**MODIFICATION REQUEST:
61 Mobbs Lane, Epping (Former Channel 7
Site)
(MP 10_0107 MOD 1)**

Director-General's
Environmental Assessment Report
Section 75W of the
Environmental Planning and Assessment Act 1979

October 2011

B1 Elevations (A1005-A) Rev A – North Elevation

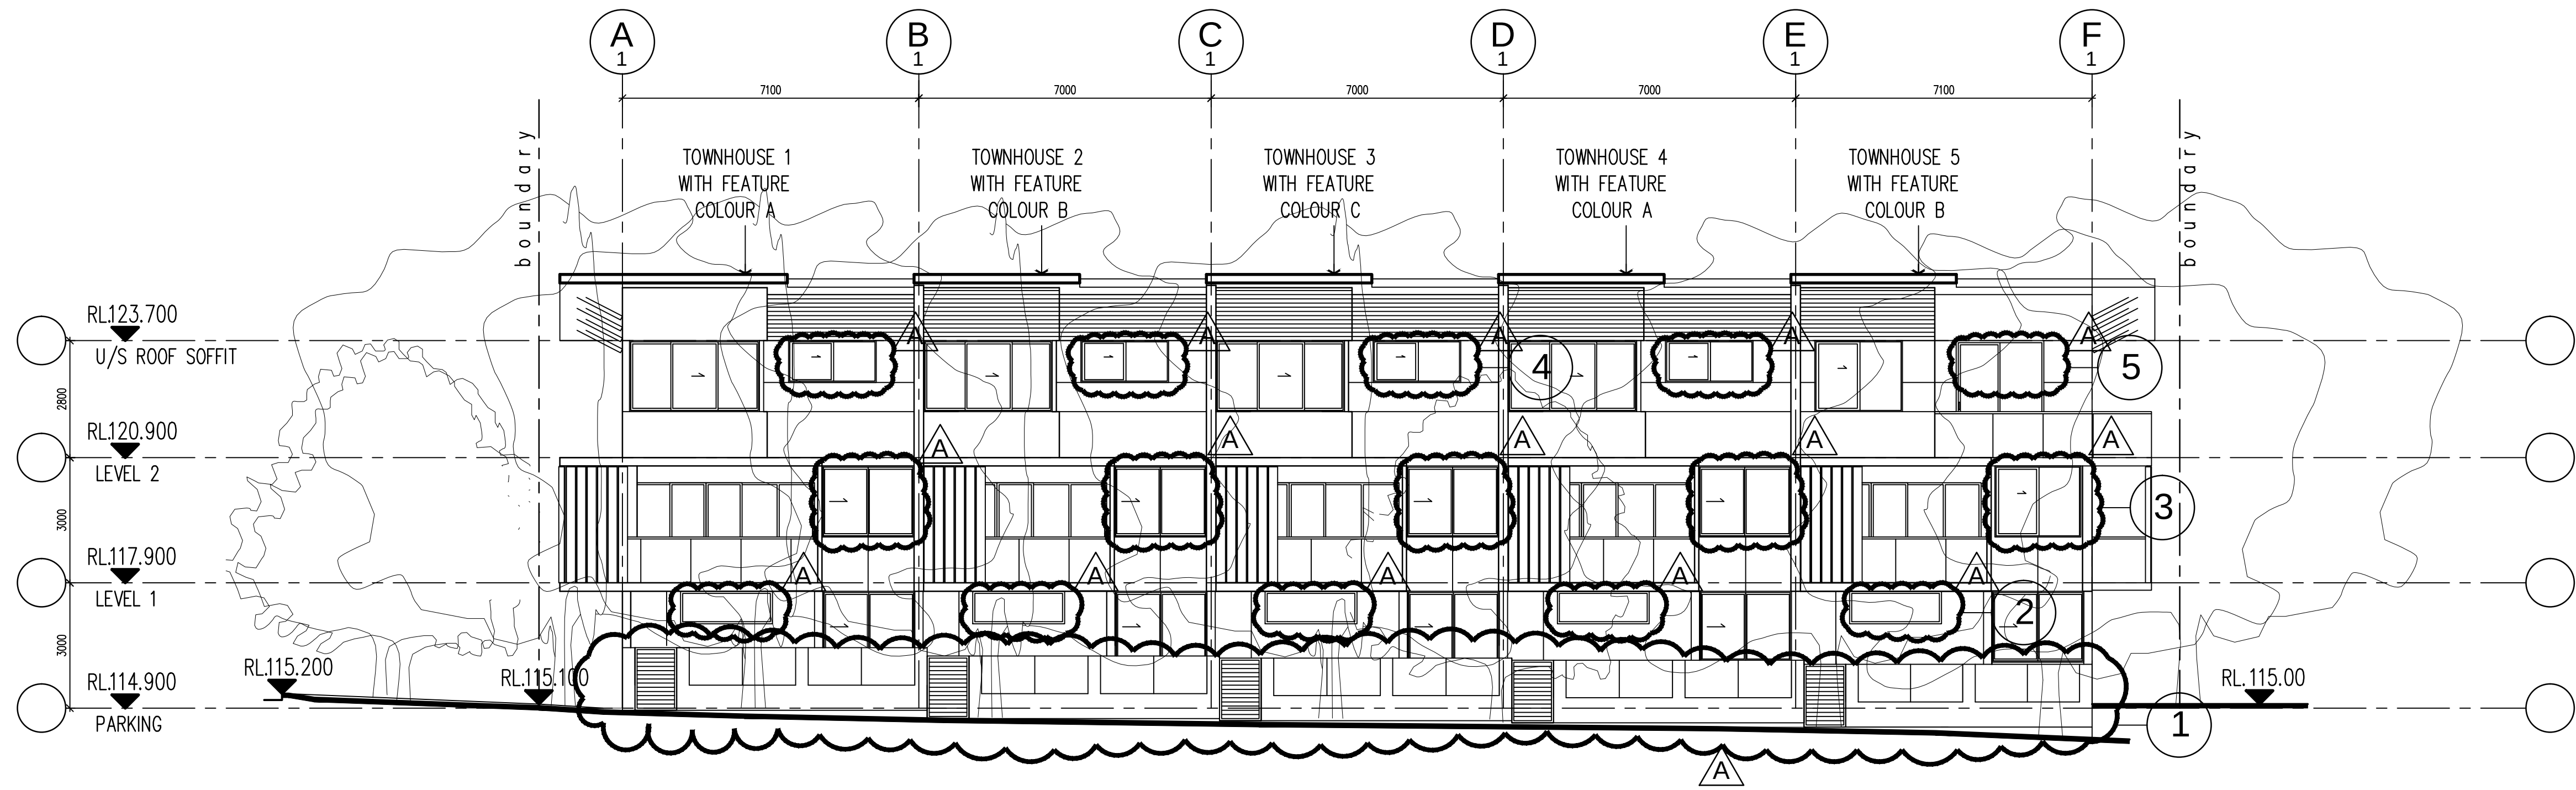
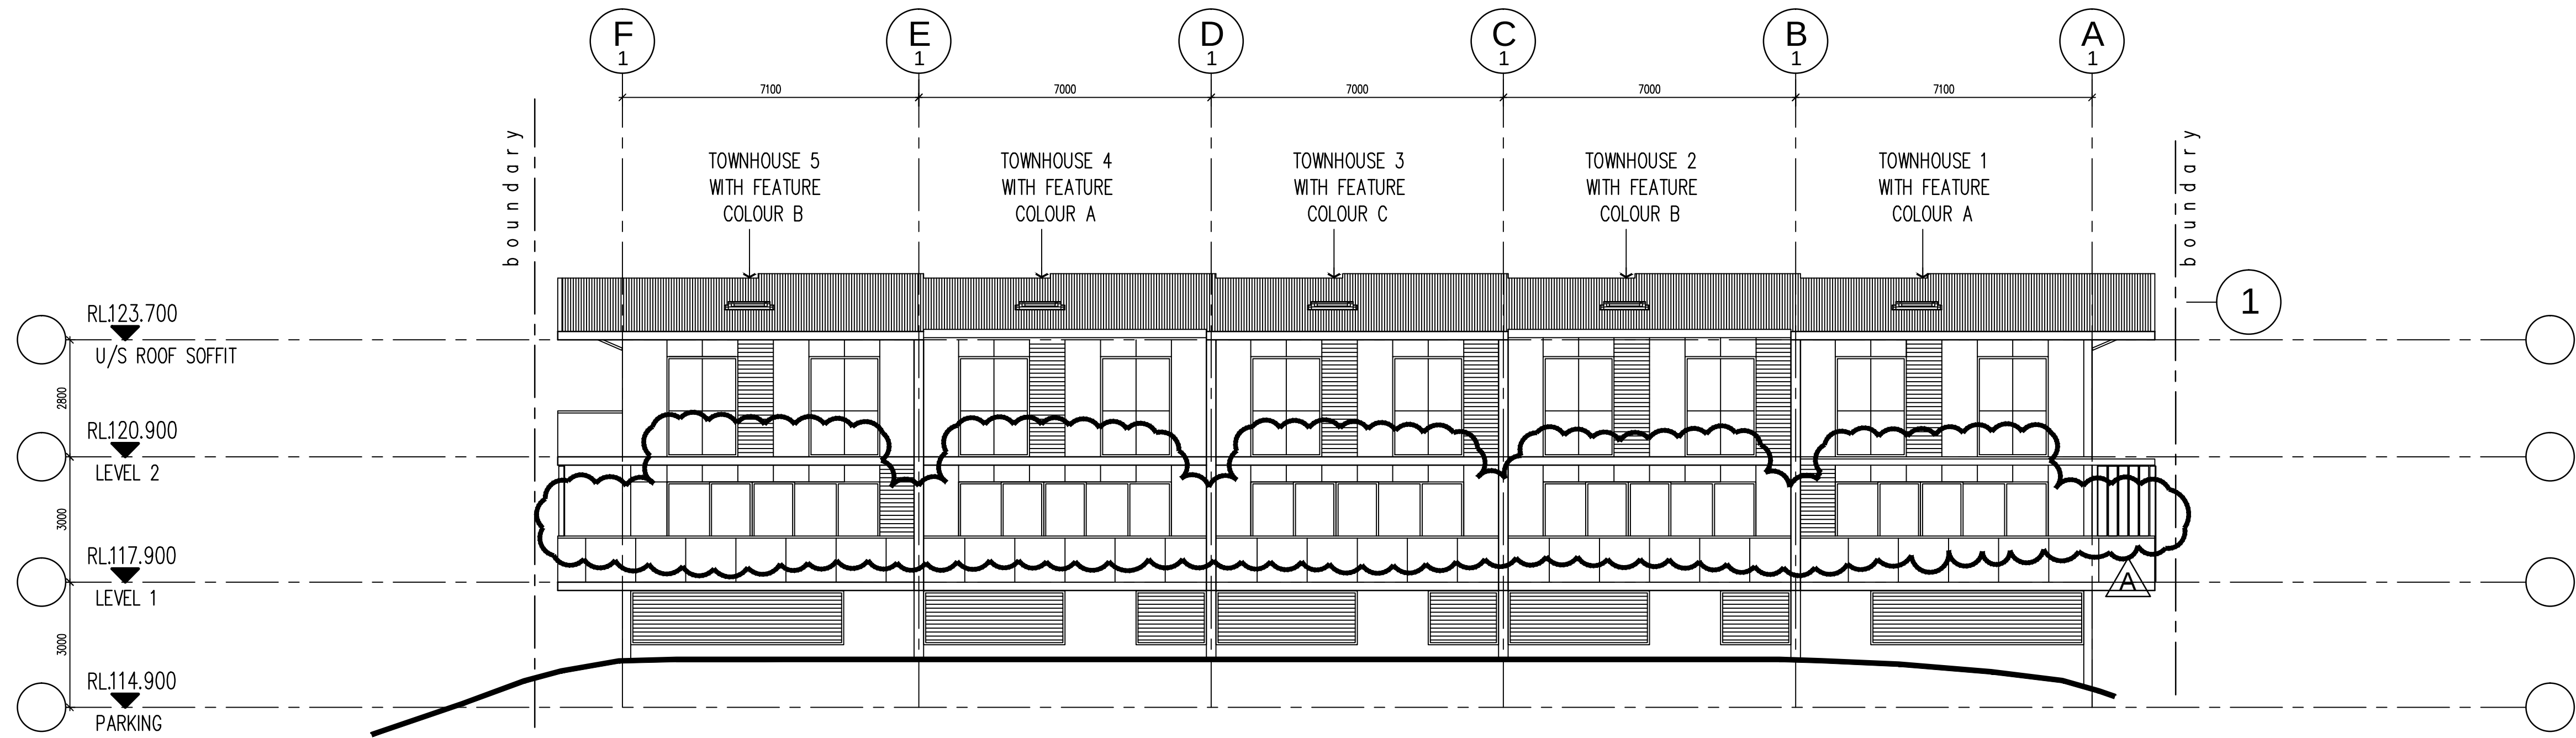
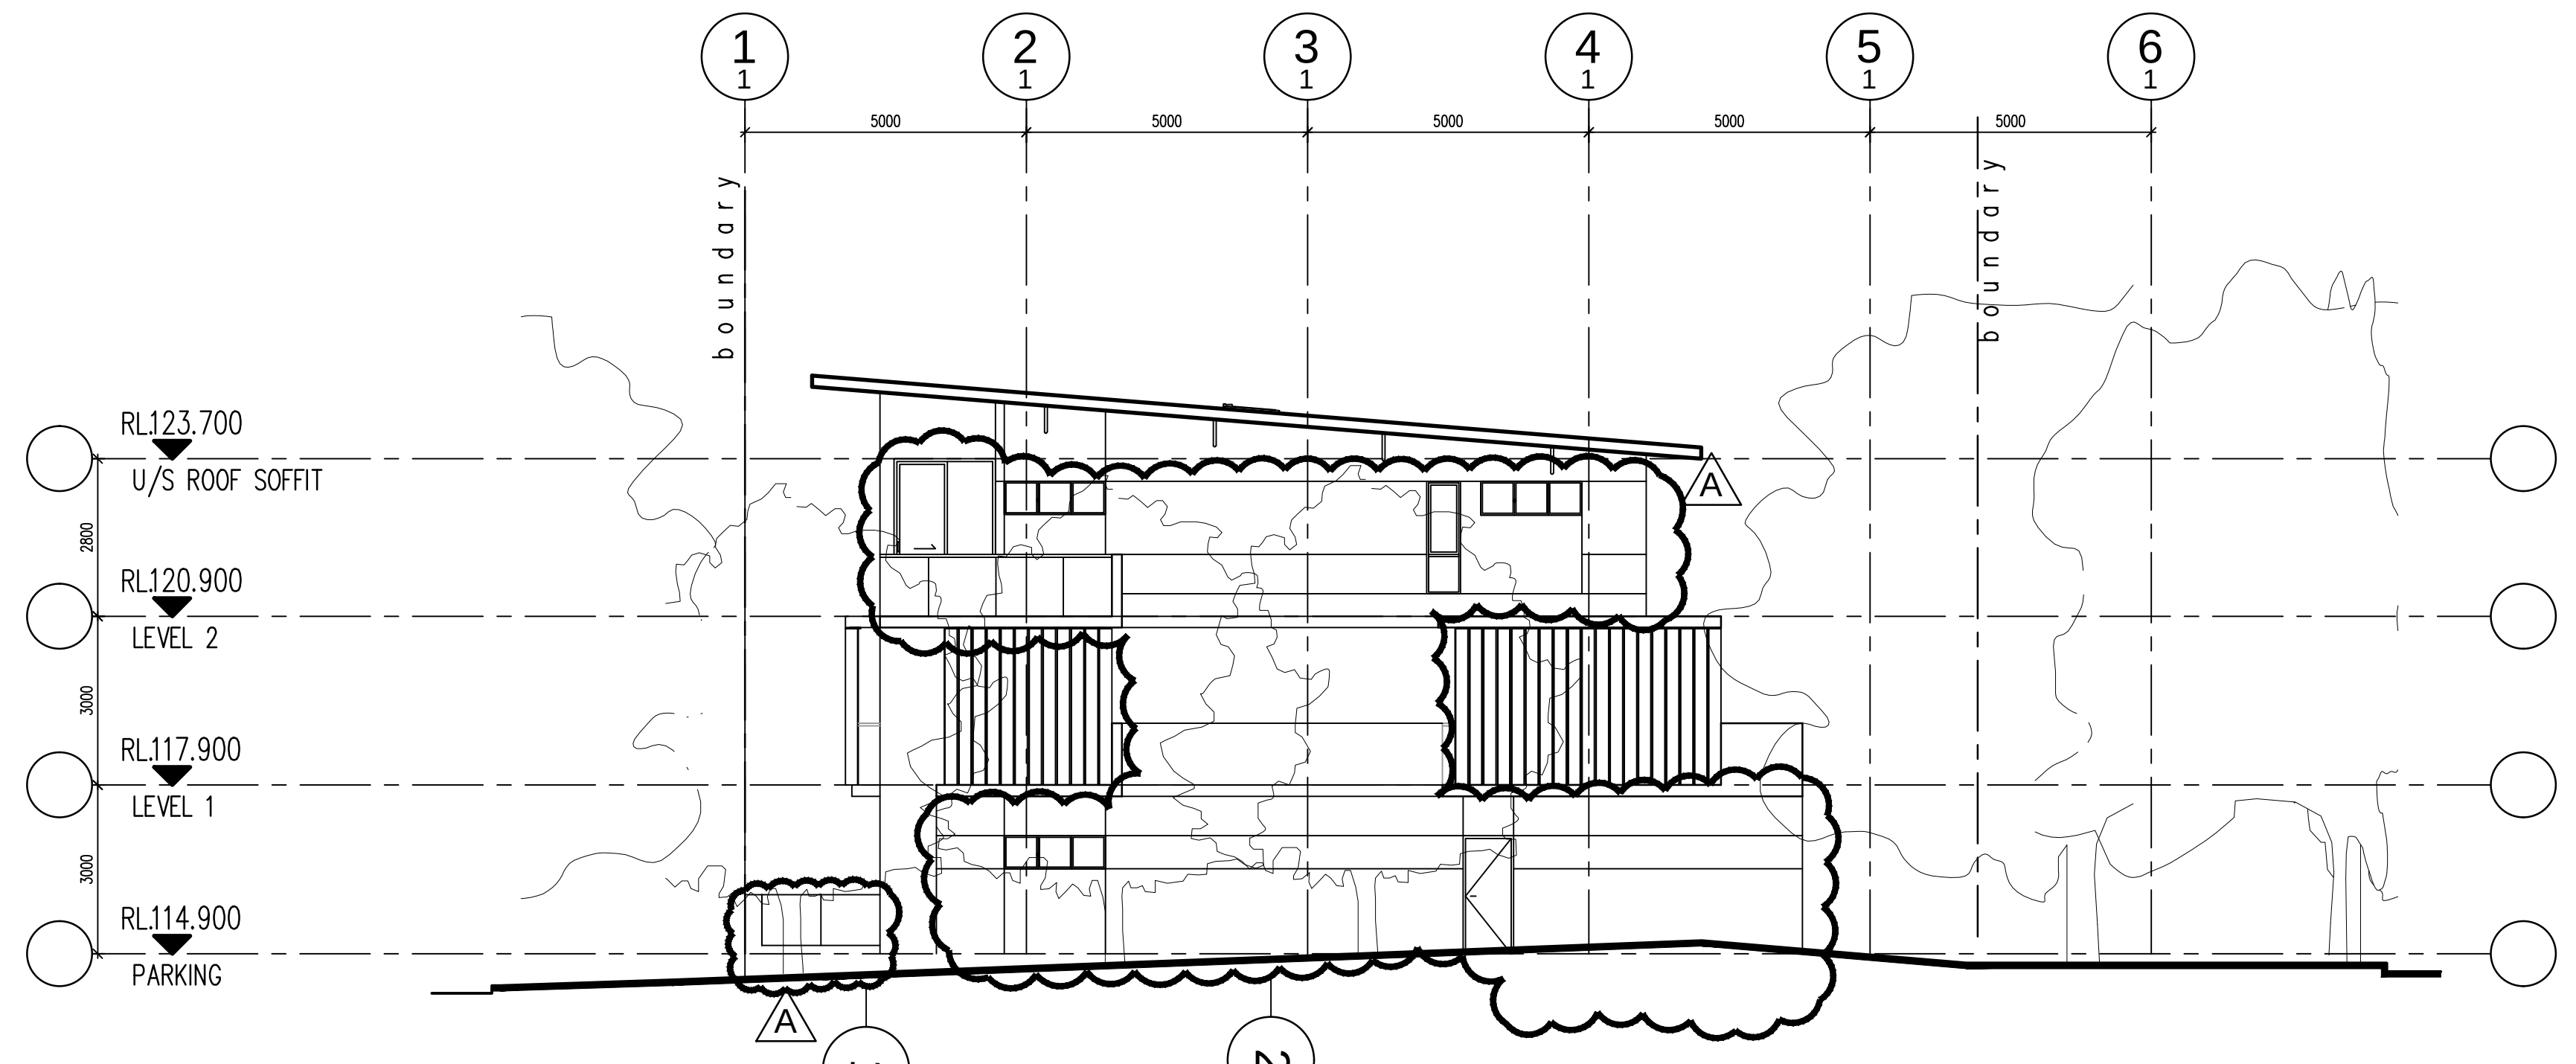
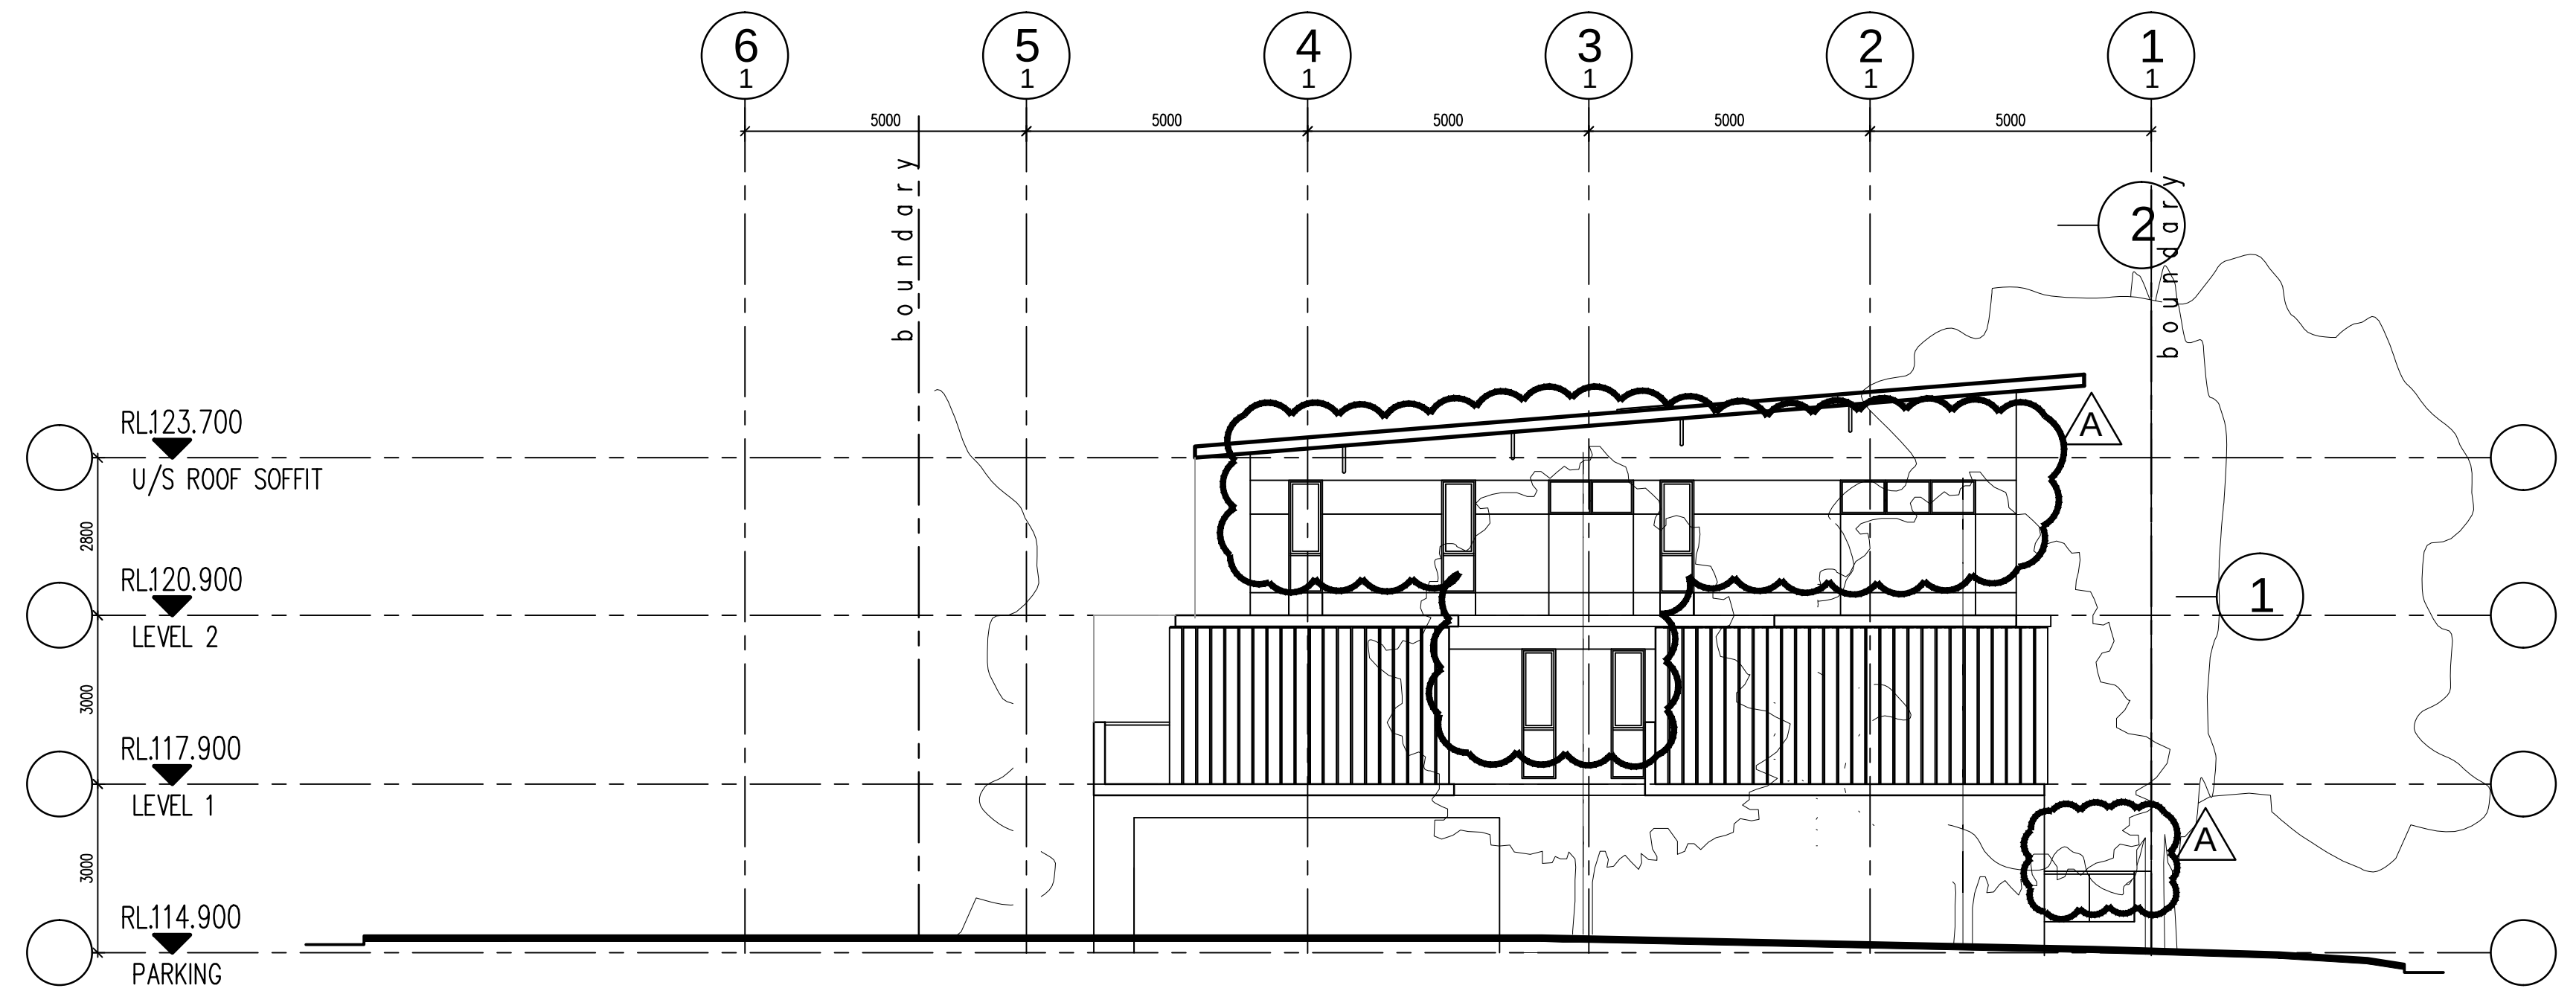
<i>B1 Roof Plan (A1004-B) Rev A</i>	<ul style="list-style-type: none"> • units 1-5 skylights reduced from 3 to 1
<i>B1 Elevations (A1005) Rev A – North Elevation</i>	<ul style="list-style-type: none"> • new glass and masonry courtyard fence 1.8 m • units 1-5 new highlight windows • units 1-5 (level 1) new window configuration • units 1-4 (level 2) new window configuration • unit 5 new sliding door
<i>B1 Elevations (A1005-A) – West</i>	<ul style="list-style-type: none"> • new glass and masonry courtyard fence 1.8 m

Plan	Description
<i>Elevation</i>	<ul style="list-style-type: none"> additional grooves in wall (all levels) and new window configuration
<i>B1 Elevations (A1005-A) – South Elevation</i>	<ul style="list-style-type: none"> units 1-5 sliding doors reconfigured and frameless glass balustrades
<i>B1 Elevations (A1005-A) Rev A – East Elevation</i>	<ul style="list-style-type: none"> new glass and masonry courtyard fence 1.8 m additional grooves in wall (all levels) and new window reconfiguration
<i>B1 Elevations (A1005) Rev A – North Elevation</i>	<ul style="list-style-type: none"> new glass and masonry courtyard fence 1.8 m units 1-5 new highlight windows units 1-5 (level 1) new window configuration units 1-4 (level 2) new window configuration unit 5 new sliding door
<i>B1 Elevations (A1005-A) – West Elevation</i>	<ul style="list-style-type: none"> new glass and masonry courtyard fence 1.8 m additional grooves in wall (all levels) and new window configuration
